About the application

Application number: 2026/90452	
What is the application for?:	Erection of dwelling and associated works
Address of the site or building:	Land adj, Lower Common Lane, Scissett, Huddersfield, HD8 9HL
Postcode:

Proposed Site Plan 1:200

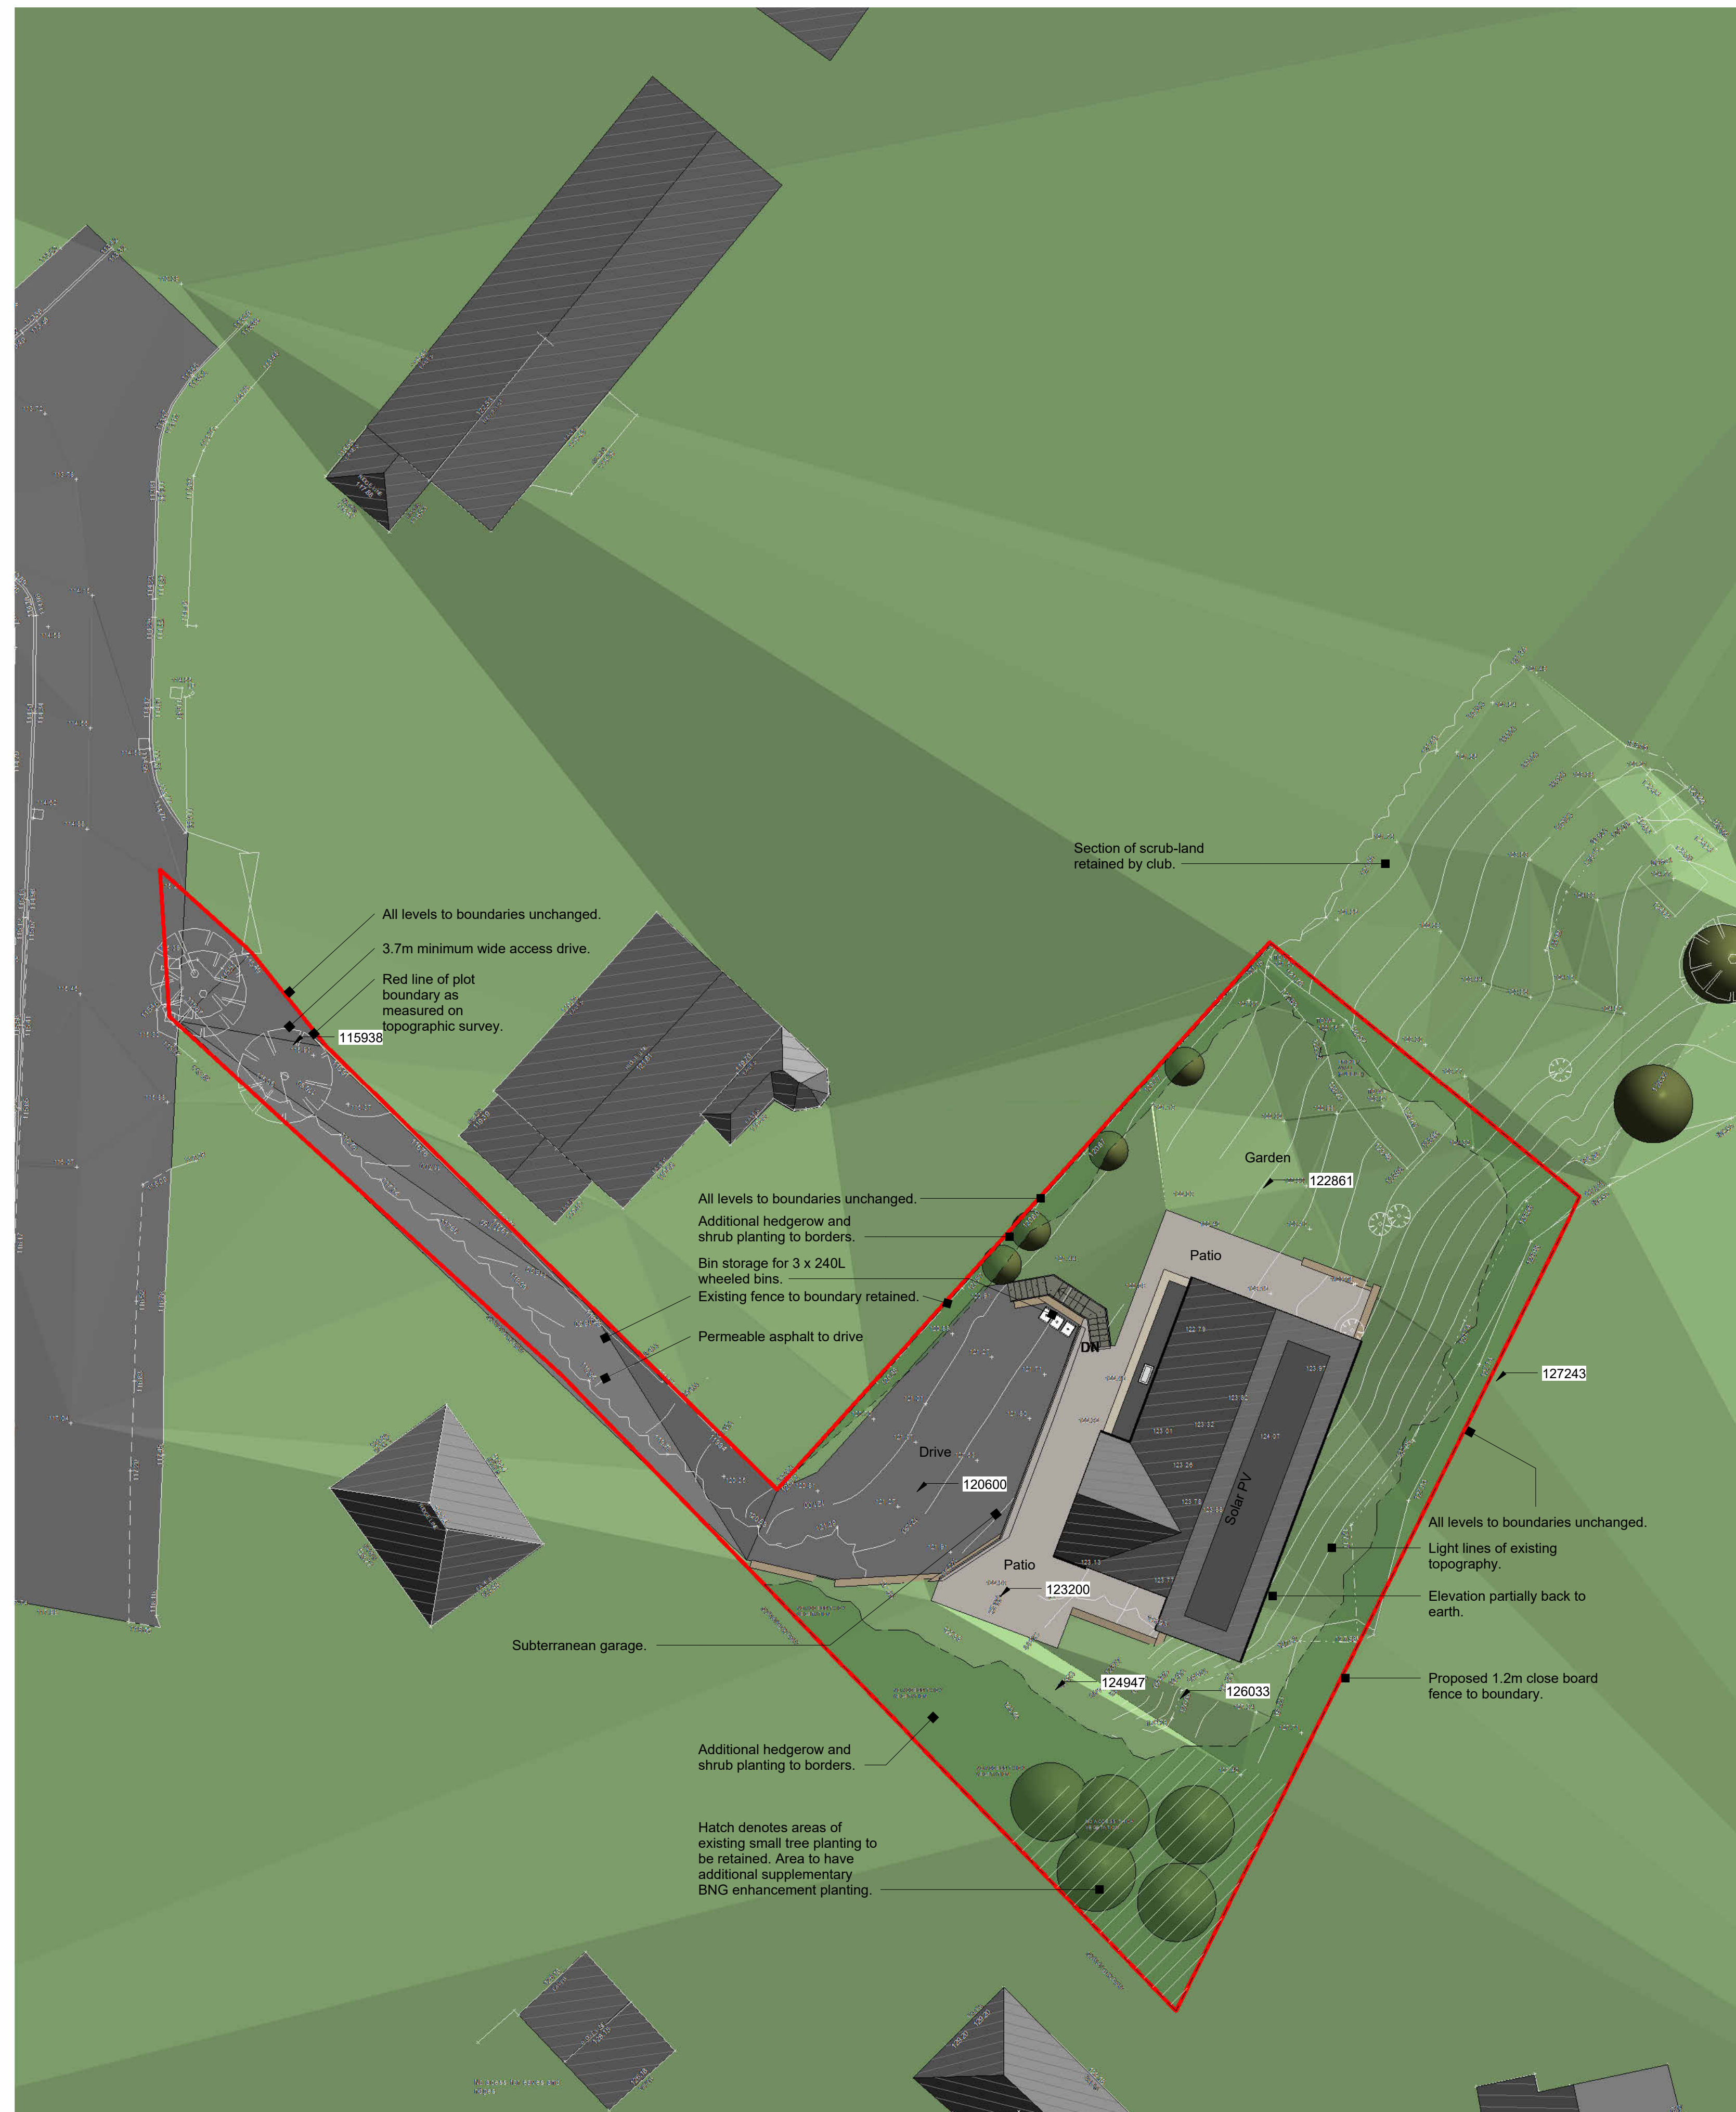
Type of comment: An objection	
Do you wish your comments to be published on the website anonymously?	Yes
<p>This objection to planning being granted is purely down to the access/driveway proposed position. The access is to be positioned between two existing driveways which would effectively combine them into one. A splayed line of site might not be achievable due to existing boundary wall and trees allowing safe joining on to the road. The driveway would also be situated opposite a popular and very busy children's nursery as this business doesn't have enough parking for parents dropping of there toddlers and staff members using the highway to park on for most of the day with parents unloading there children reduces the road to a single lane. The main junction from Lower common Lane onto Barnsley Road is approximately 15m from proposed drive this at times is a busy junction and vehicles turning on to Lower Common Lane have to contend with vehicles entering and exiting the children's nursery, parked vehicles on the right hand side, vehicles coming down the hill on the wrong side of the road due to cars parked and vehicles pulling out of existing driveways.</p> <p>Also on the plans the width of proposed driveway has been provided which is questionable in regards of being an accurate measurement near to the entrance, further up the proposed drive the width narrows significantly which in my view would then allow for emergency vehicles to have access to the proposed property and this had to be taken in to consideration fo a new development especially when the property is of a great distance from the road.</p>
